4.0 ROOFING SYSTEM

3.3 Deck(s)

FOUNDATION SURVEY
 FOR
H & H HOMES
 ANDERSON CREEK CLUB
 LOT 145
 FALLS CREEK DRIVE
 NORTH CAROLINA
 HARNETT COUNTY ANDERSON CREEK TOWNSHIP

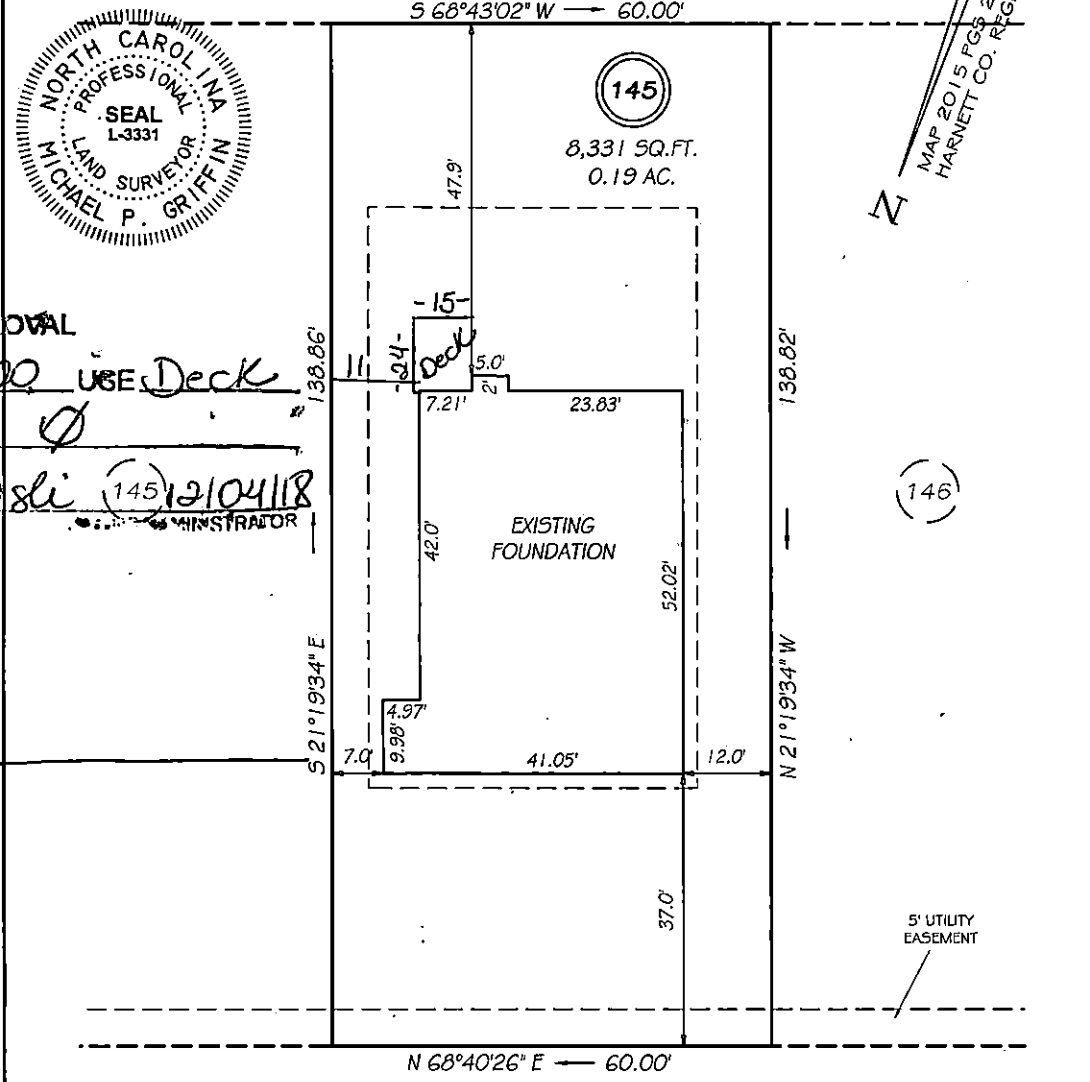
3.3.2 Deck supports were installed using non standard building practices and appear to be inadequate. An improperly supported deck is prone to leaning, tipping, and could slide from its support base causing injury or property damage. Recommend consulting a GC or deck specialist to evaluate the structure and improve support as needed. (Exterior Back)
